# **COUNTY COUNCIL'S RESPONSE TO CONSULTATION ON THE FOLLOWING DEVELOPMENT PROPOSAL**

**Application No:** 18/01246/F

**Proposal:** Change of use of premises from B8 to B1c/B2/B8, including internal and external alterations, demolition of ancillary structures and new access to Southam Road.

## Transport Schedule

Site Plan (Location of Proposed Cycle and Smoking Shelter)

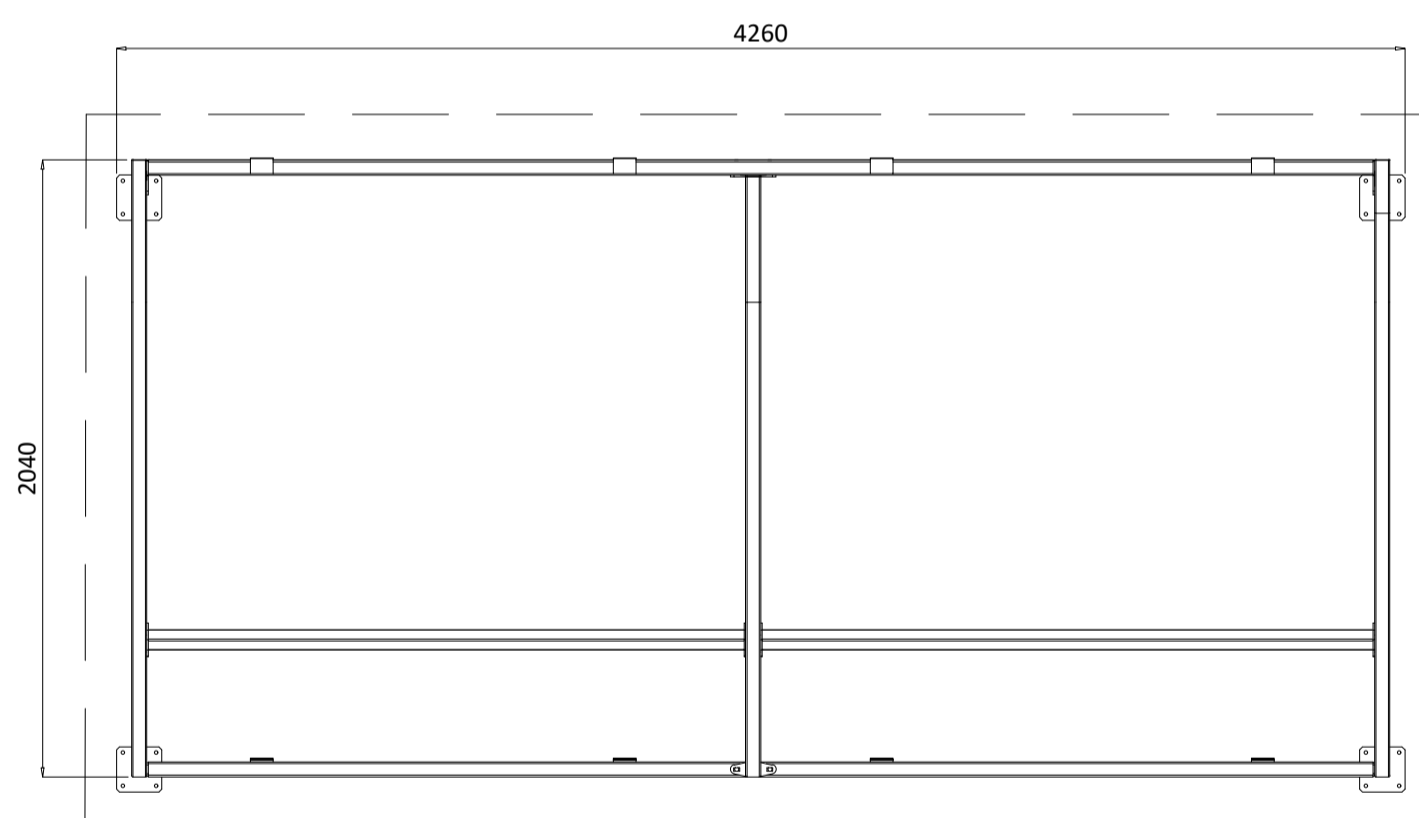
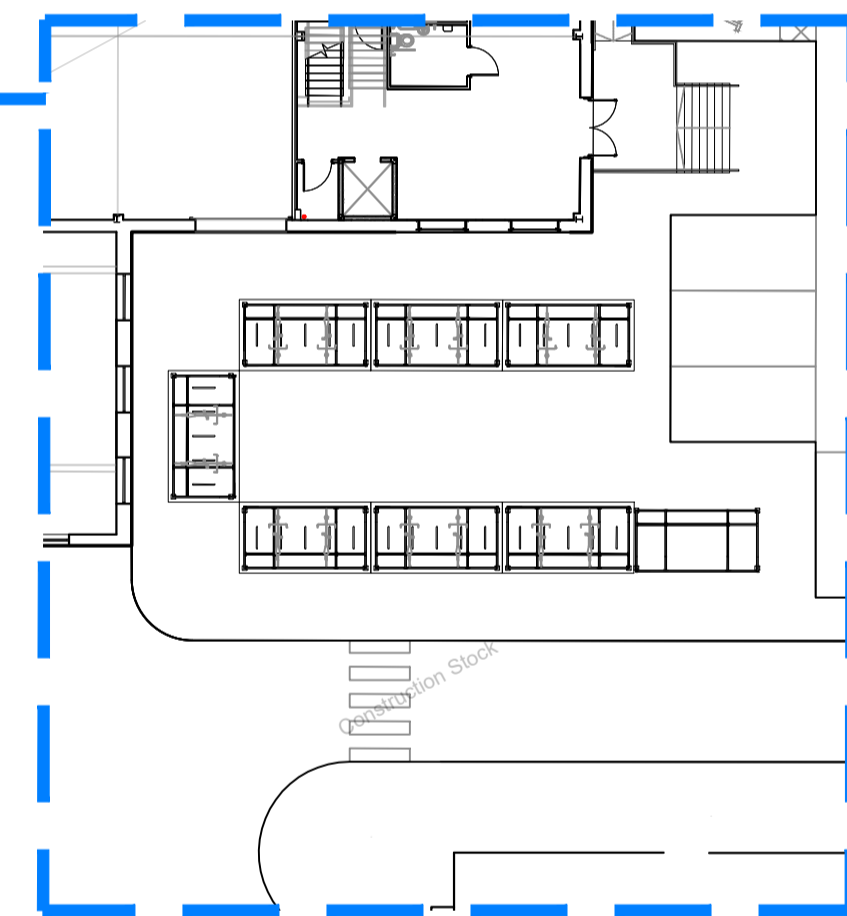
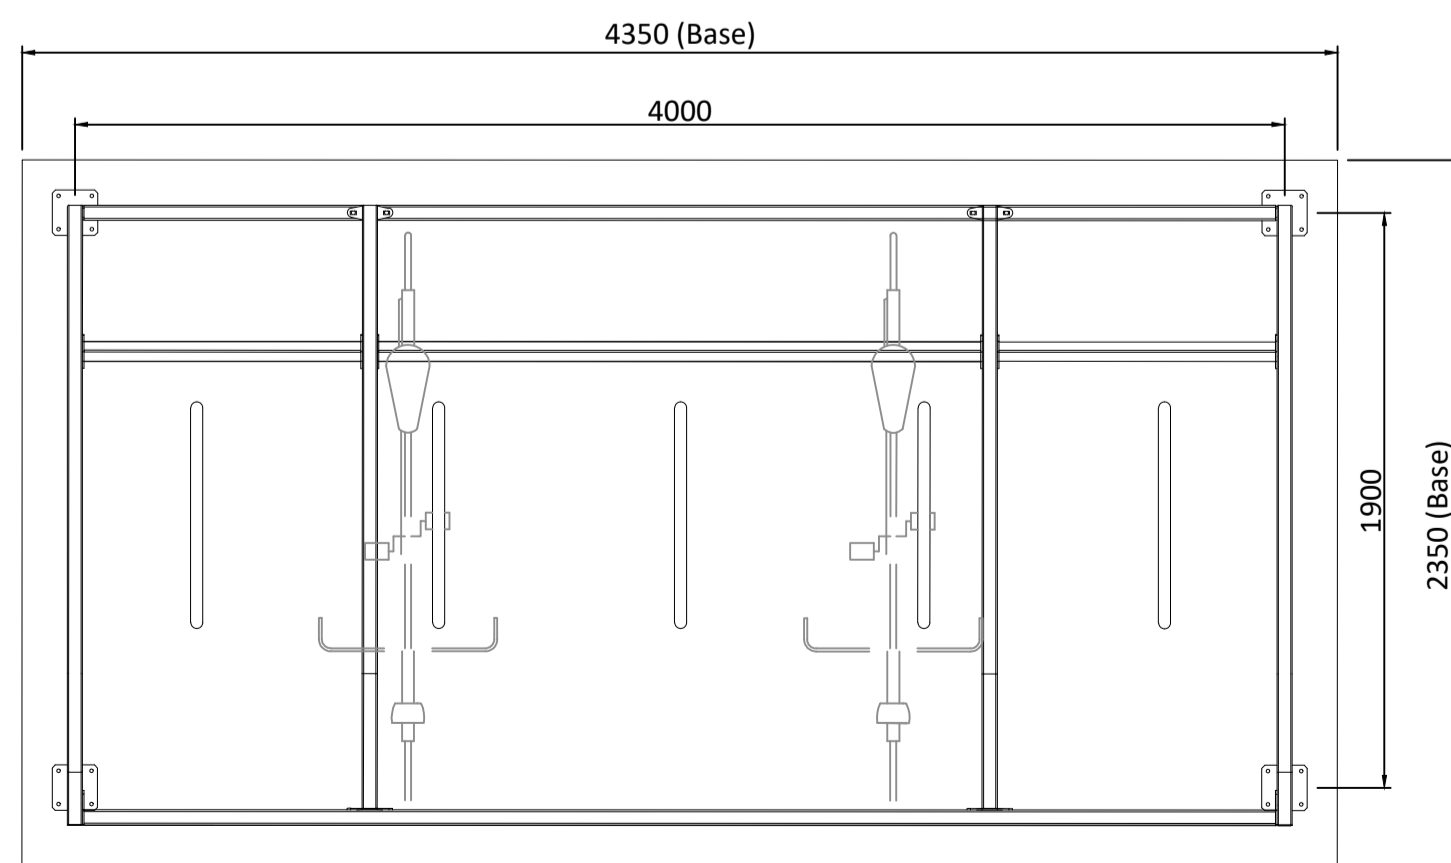
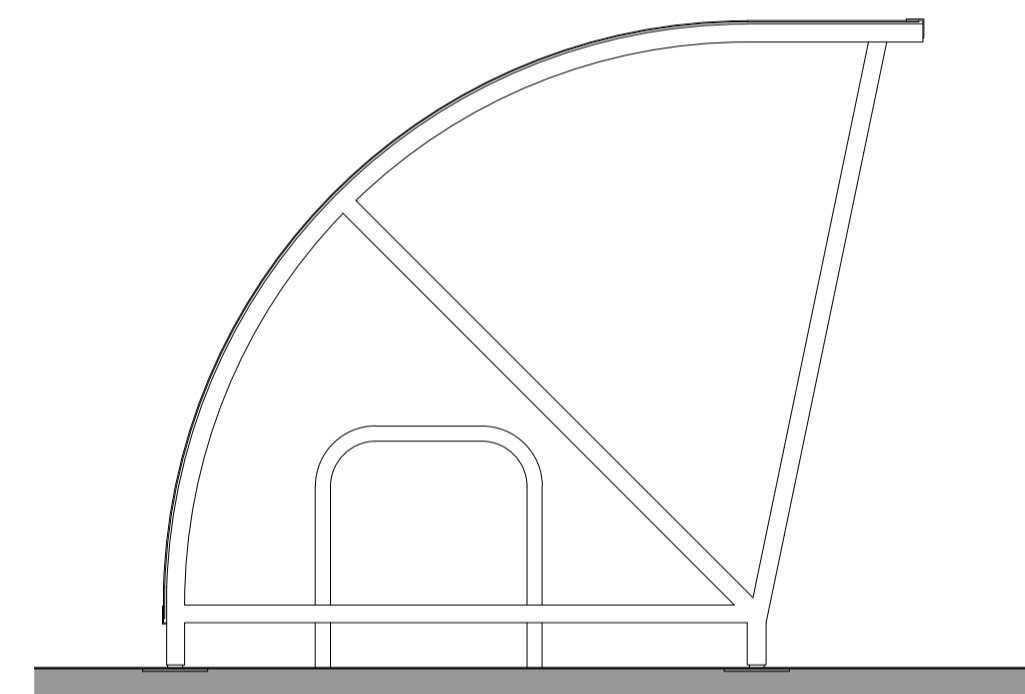
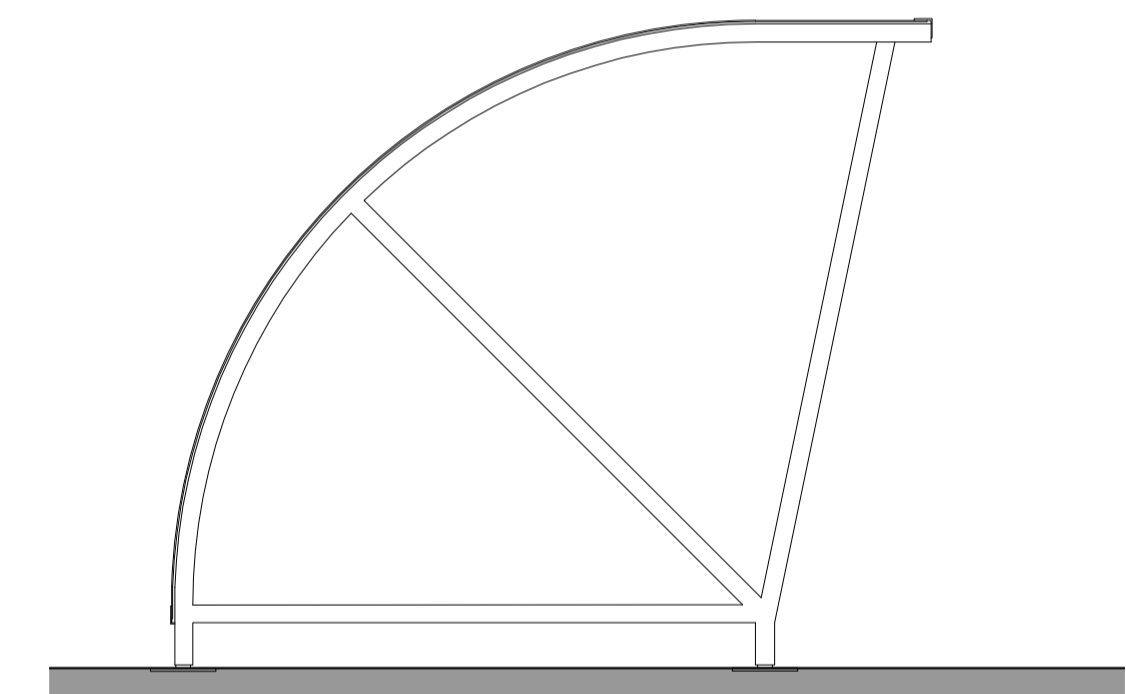
The application including the site plan have not been clear on the detail of cycle parking facilities on site. In my view there should be adequate covered cycle facilities preferably in close proximity to the building entrance to avoid cyclists having to negotiate the car parking areas if at all possible.
